**From:** Rhiannon Lloyd  
**Sent:** 12 November 2025 16:19  
**To:** Planning.Responses  
**Subject:** FW: LU/217/25/HH 8 GRIFFIN CRESCENT - SUB PLAN  
**Attachments:** Existing and Proposed Plans\_Amended.pdf

**Subject:** LU/217/25/HH 8 GRIFFIN CRESCENT

PROPOSED BLOCK PLAN
1:500

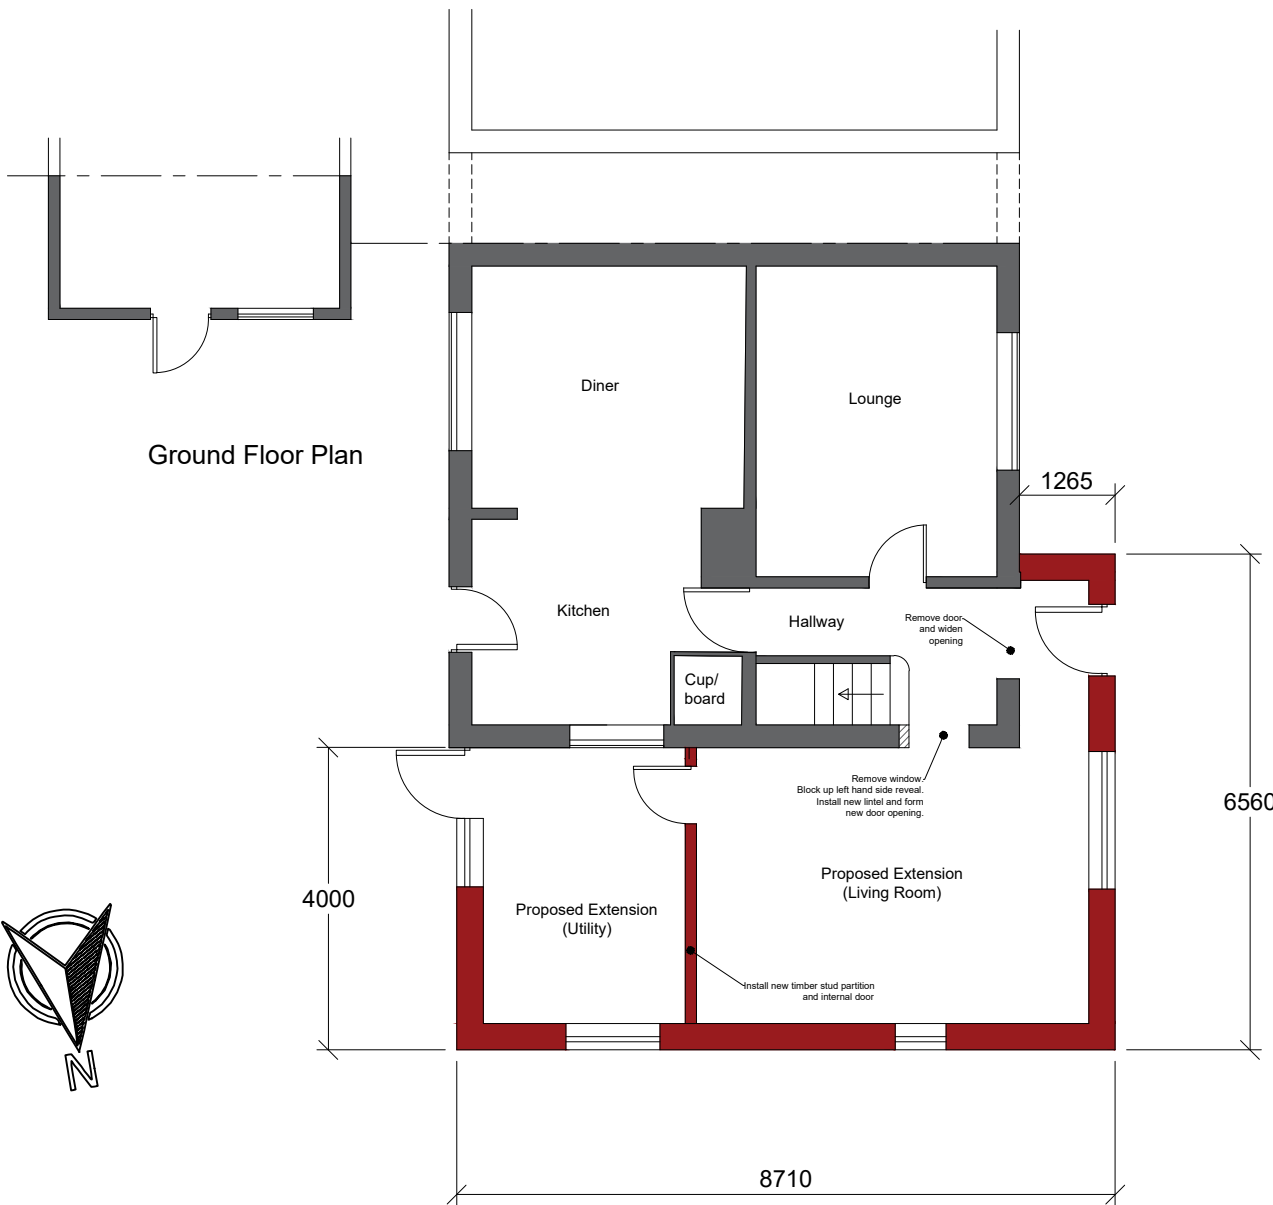
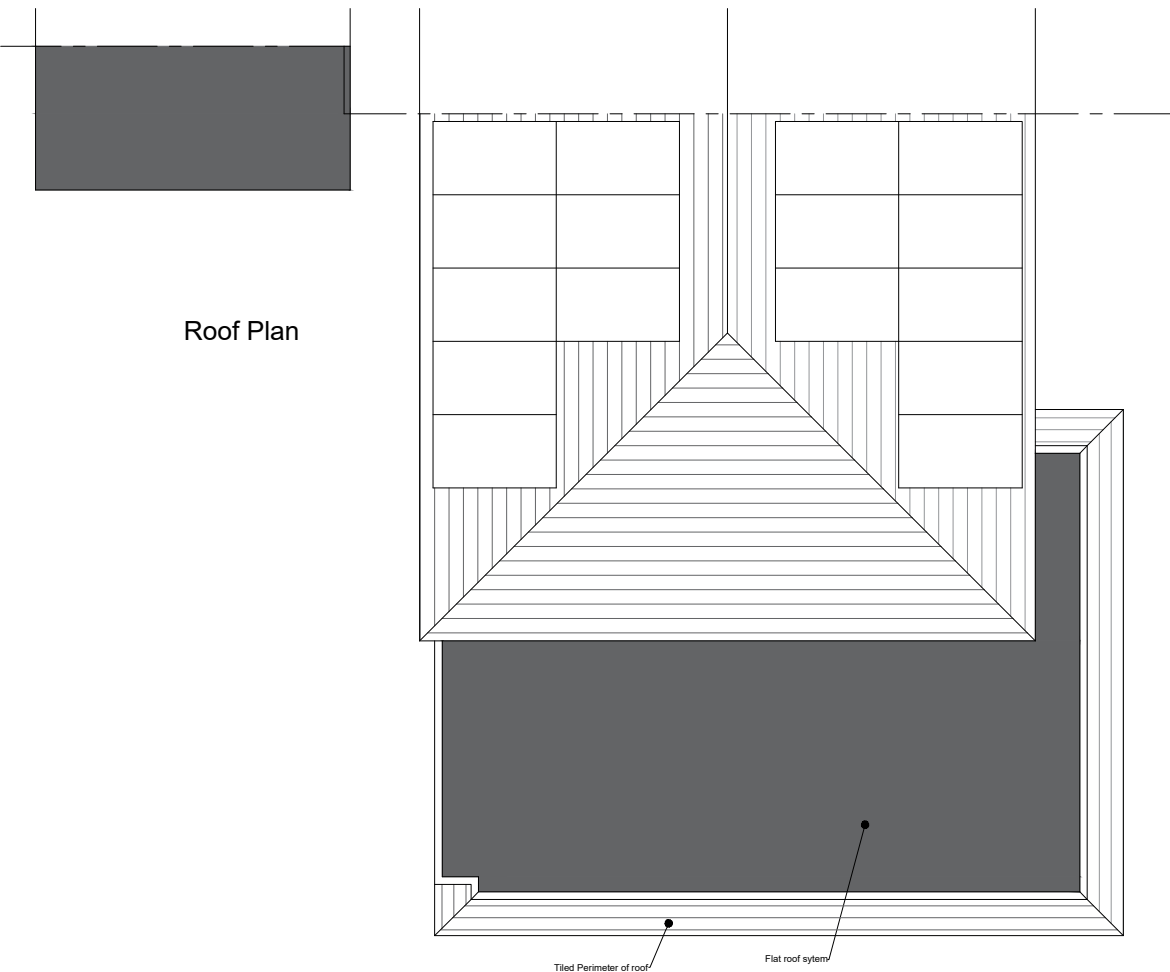
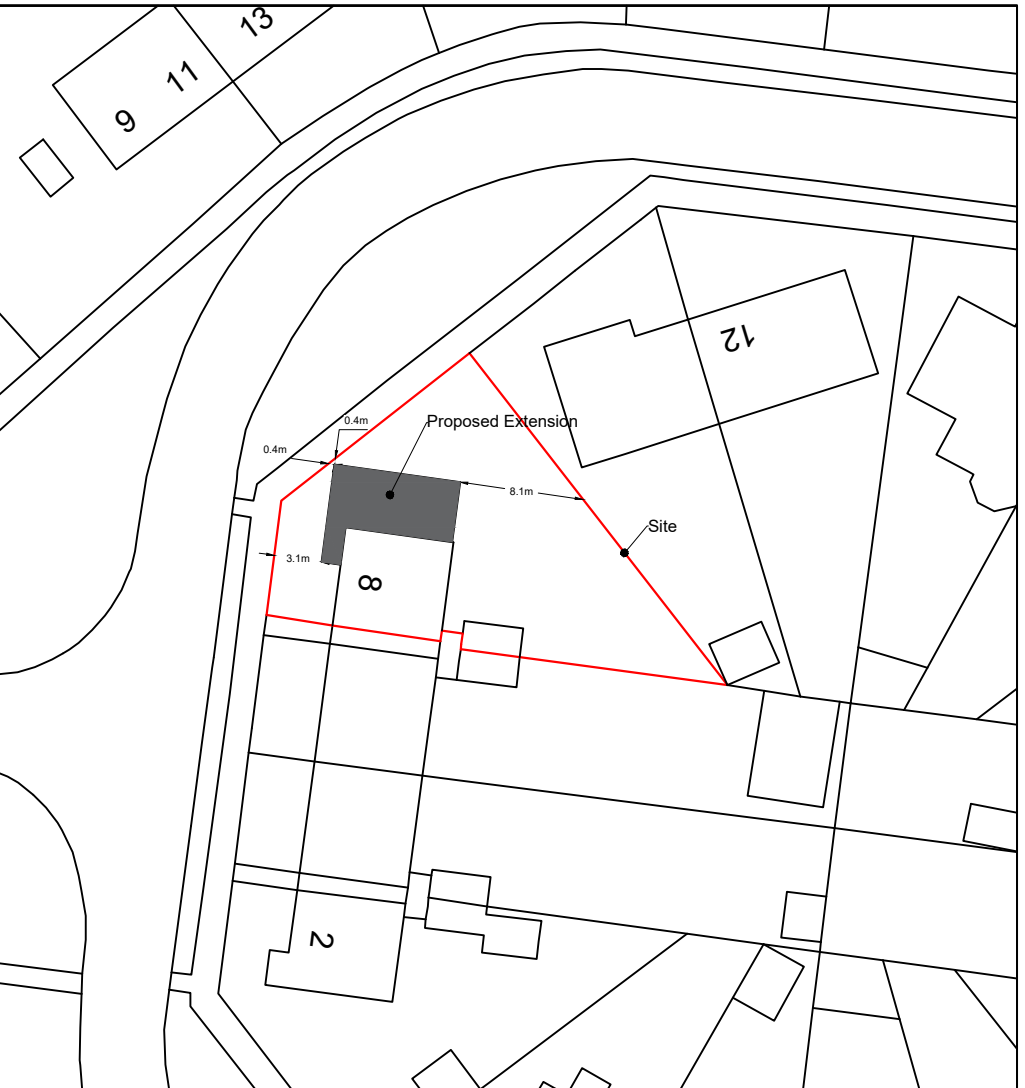
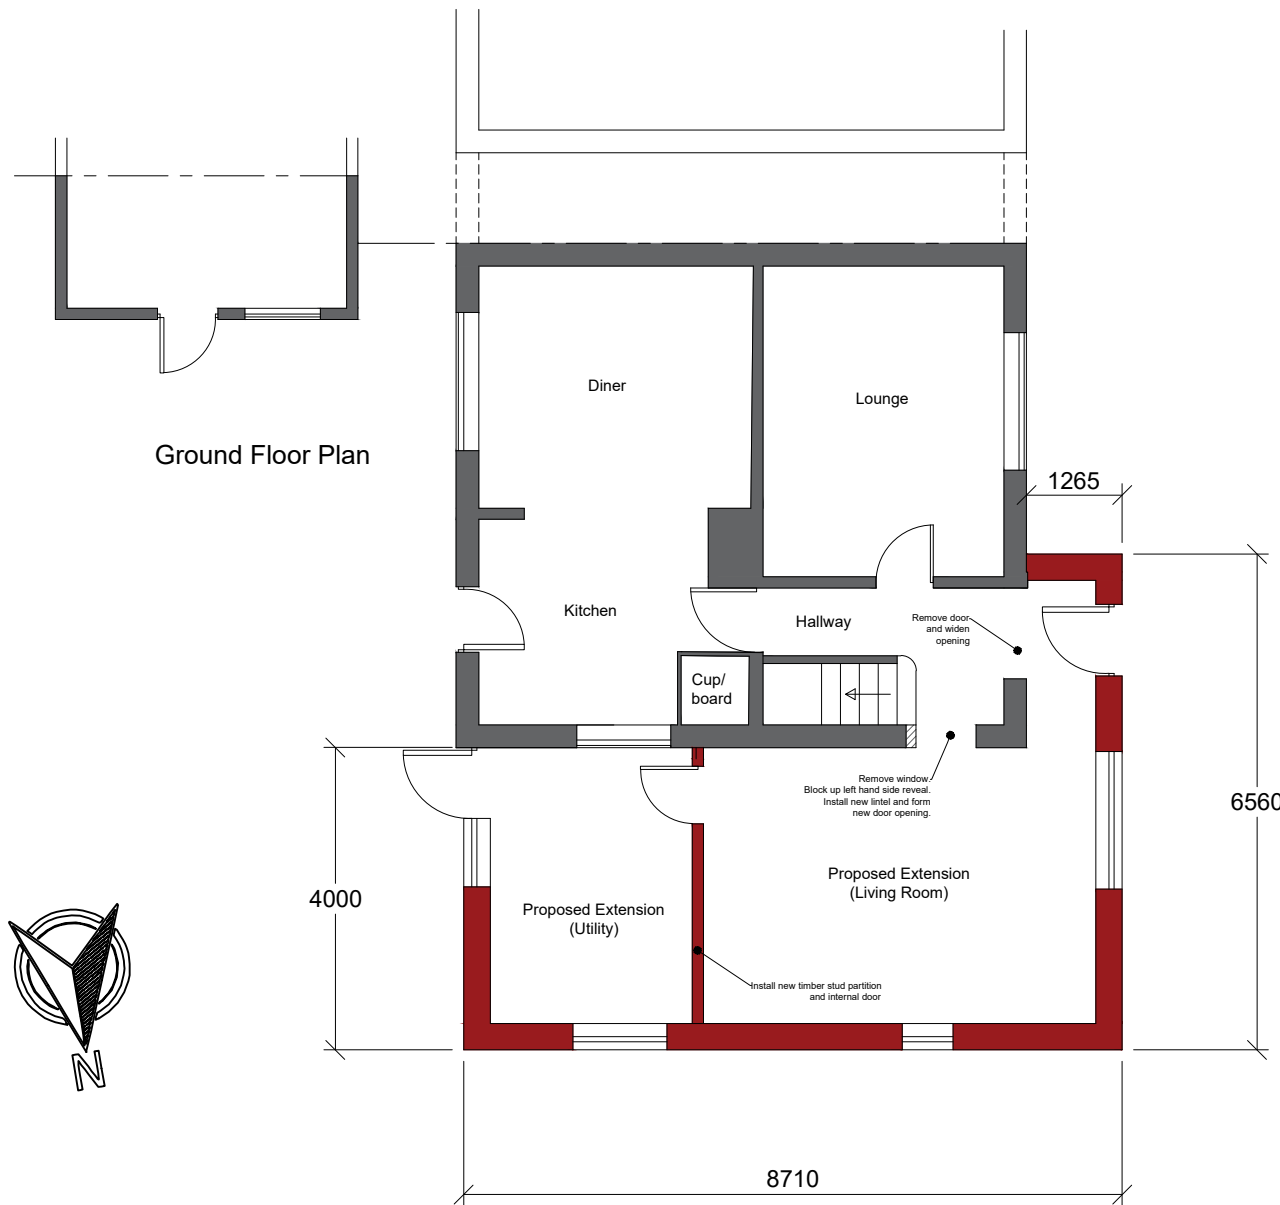
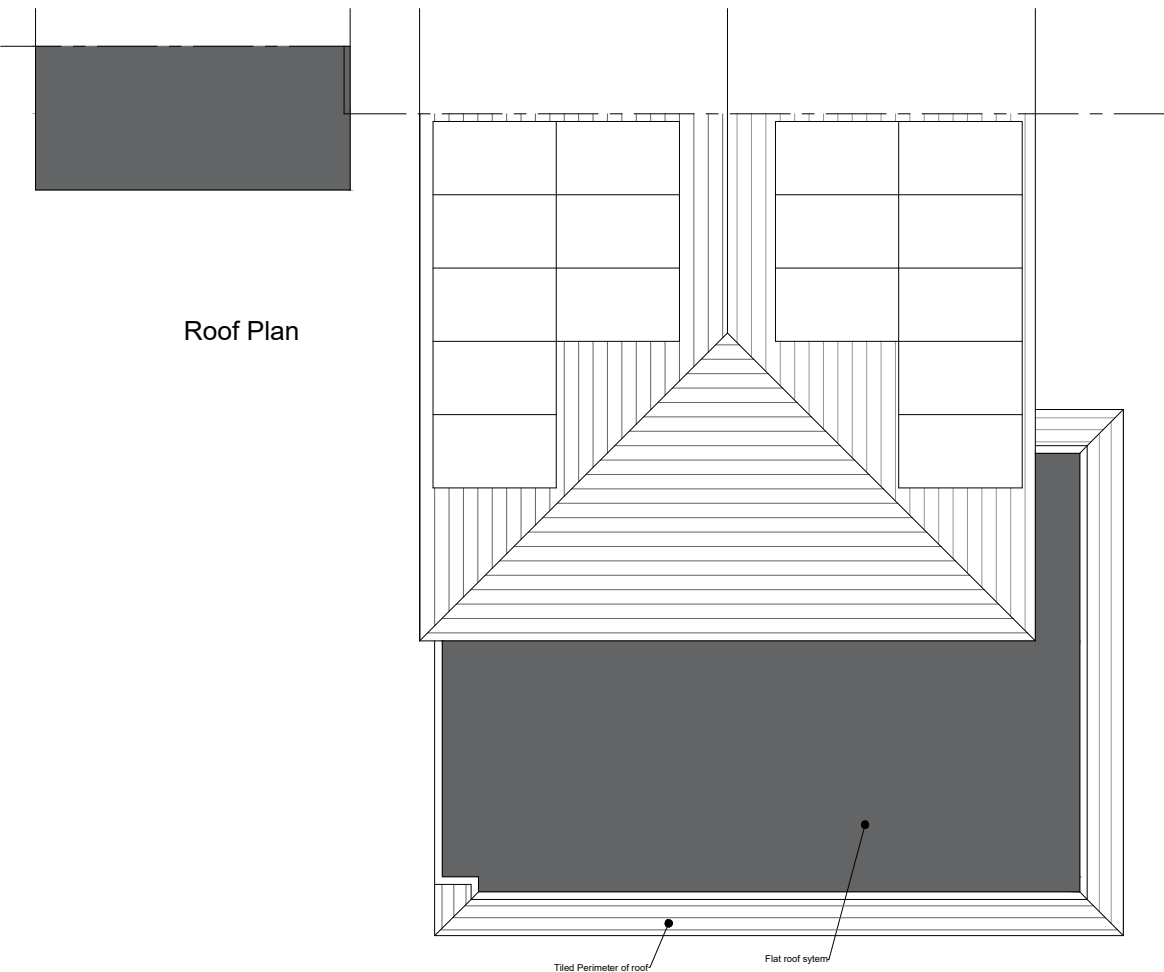
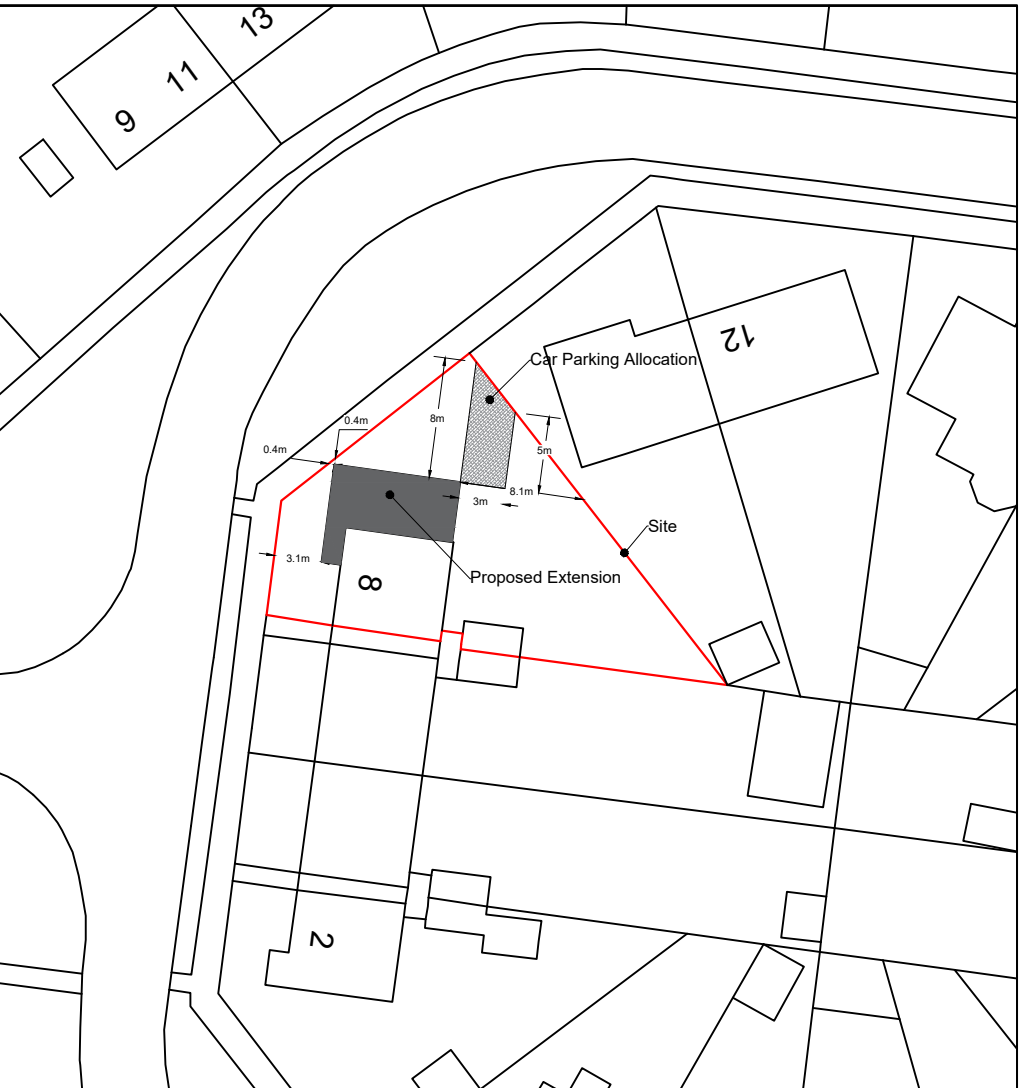
Please could you provide details of the proposed parking within the block plan. A preliminary look at the application suggest parking may be lost.

I have now attached a revised plan showing the revised parking allocation on the block Plan.

There will be ample room on the property with minimal to no impact to any amenity area.
